Pedestrian Wind Environment Statement

for the proposed development known as
Westmead Millennium Institute &
Research Hub, NSW

Report Reference No. WA947-01F03(rev0)- WS Report

FLOOR PLAN
LEVEL 01 - UPPER GROUND
DRAWING NUMBER
DA-D-01
ISSUE
7

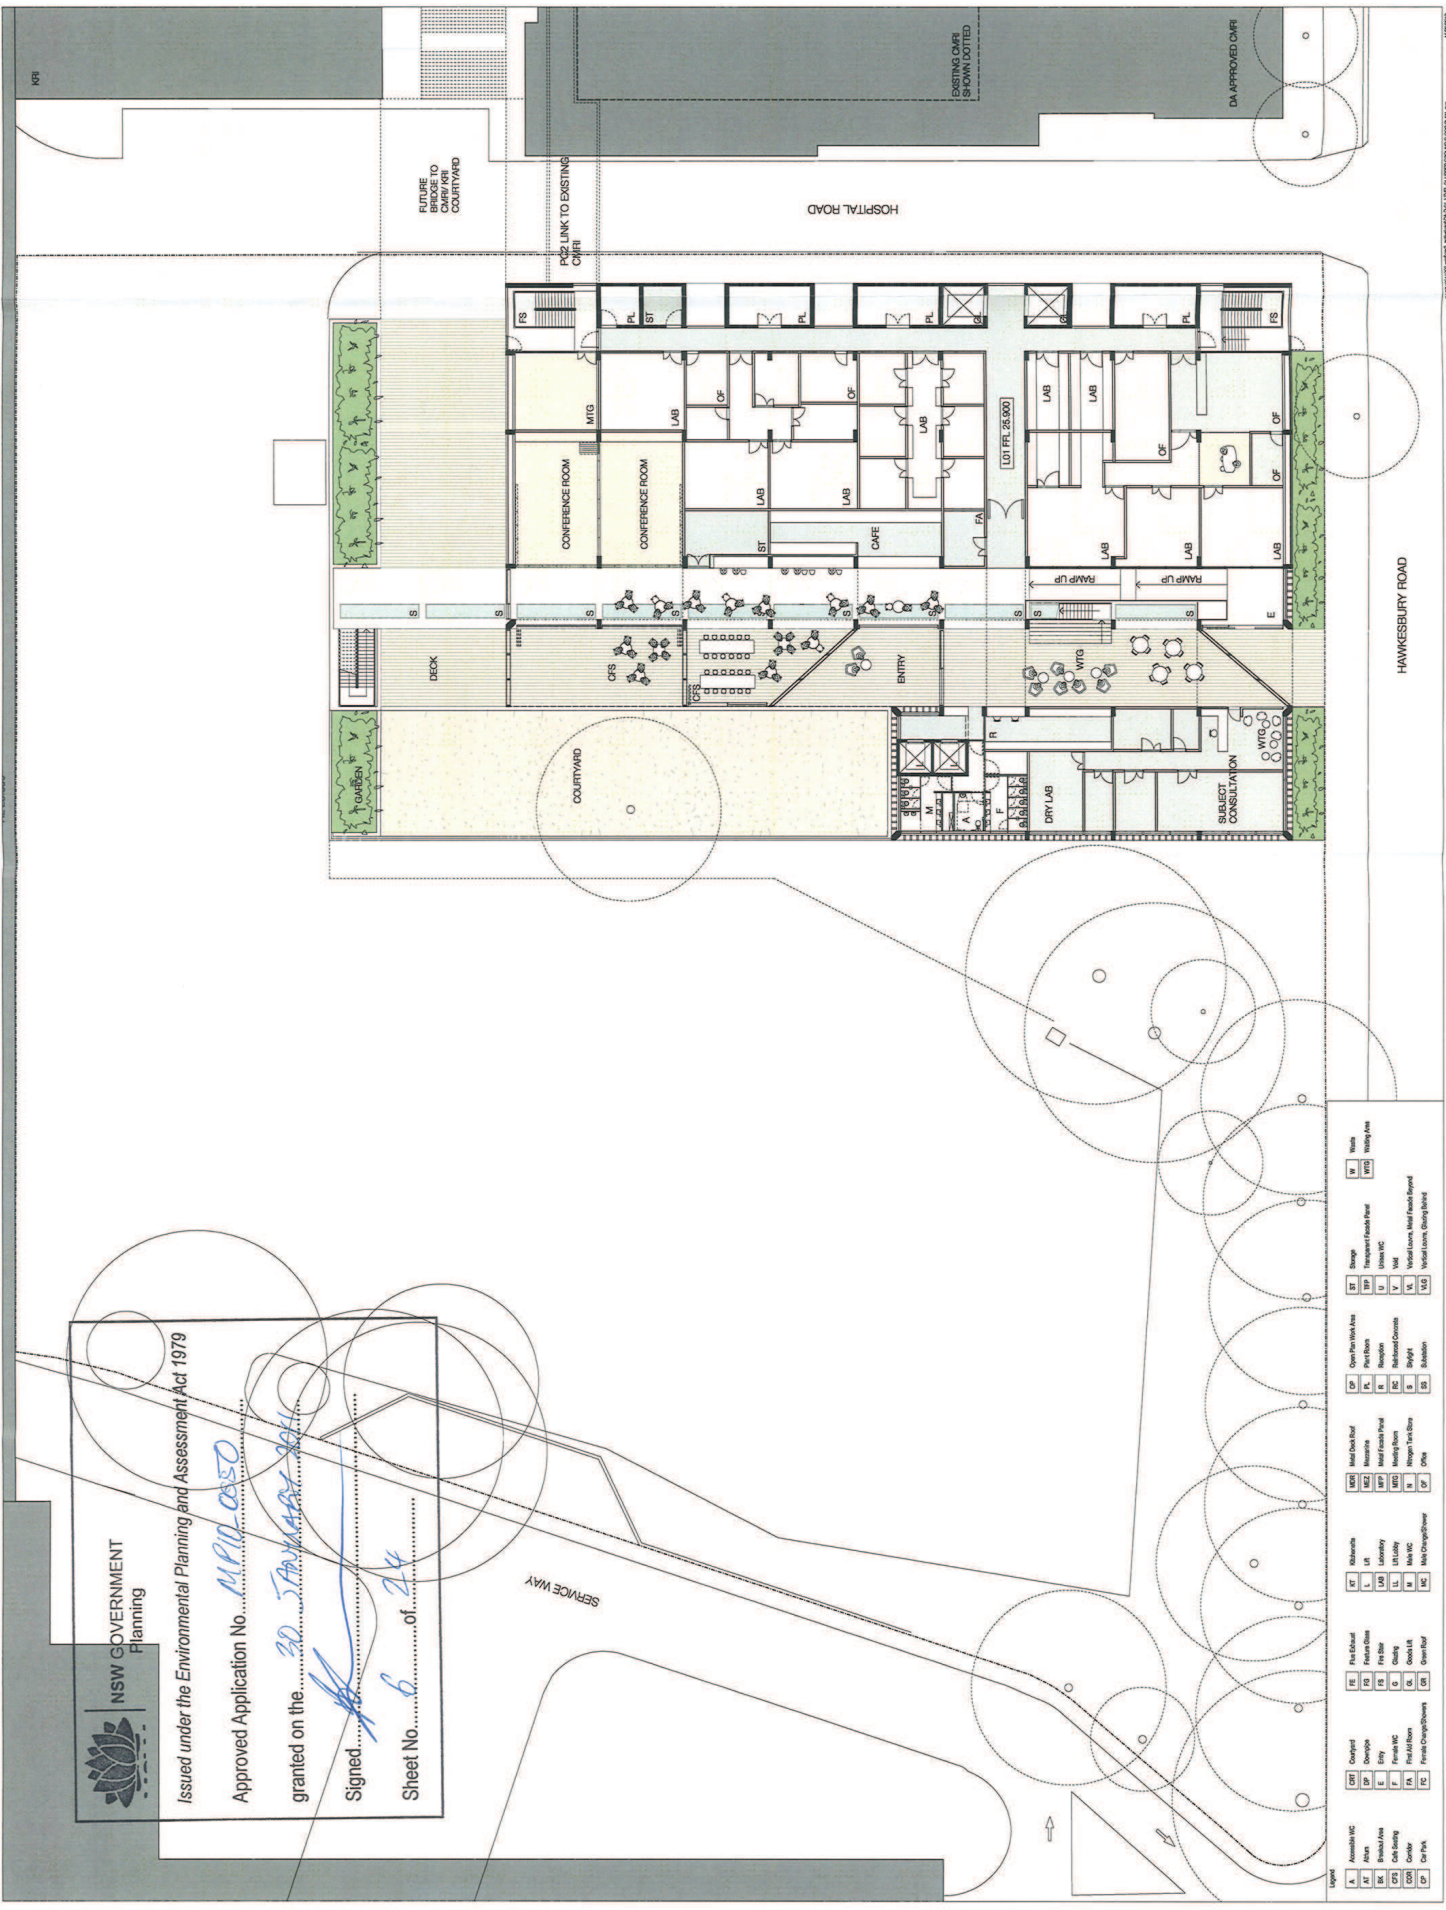
The entry to the proposed development along Hawkesbury Road is potentially exposed to adverse winds from the south. It is recommended that an impermeable screen or signage of the same height as the door be used to prevent direct southerly winds from funneling through the entrance. Two alternative arrangements are presented in Figure 3a below. Either of these recommendations are expected to mitigate the funneling of the southerly winds through the entrance.

The courtyard, garden and café seating area on Level 1 is potentially exposed to adverse winds from the south. This is caused by the lack of shielding from the neighbouring buildings to the south and side streaming of the south-westerly winds by the subject building. The proposed large tree in this area is expected to provide some protection from this wind effect. In addition, it is recommended that either 2m high impermeable screen or blade wall and/or densely foliating evergreen

trees be provided along the northern edge of this area, as shown in Figure 3b. Note that for tree to be effective in improving the wind conditions in the courtyard, they must be of a densely foliating variety and capable of growing in a windy environment.

The courtyard, garden and café seating area on Level 1 are exposed to adverse winds from the west. This is caused by the lack of shielding from the neighbouring buildings to the west. It is recommended that either 2m high impermeable blade walls and/or densely foliating evergreen trees, similar to Figure 3b, to be included in the final design to prevent direct exposure to the westerly winds. It is noted that the architectural drawings include trees planting in the courtyard. Retaining these trees in the final landscaping plan will further enhance wind conditions in these areas. Note that for trees to be effective in improving adverse wind conditions, they must be of a densely foliating variety.

- Impermeable screens or signage of the same height as the door for the entrance along Hawkesbury Road at Level 1.
- A strategic layout of 2m high impermeable screens or blade walls and/or densely foliating trees or shrubs for the Level 1 courtyard, garden and café seating area.
- It is recommended that a wind tunnel study be conducted to evaluate the impact of the proposed development on the helipad. Ameliorative measures can be tested in the wind tunnel to positively influence conditions on the helipad if required.
- It is also recommended that a wind tunnel study be conducted to determine the dispersion characteristics of the exhausts from the proposed stack.
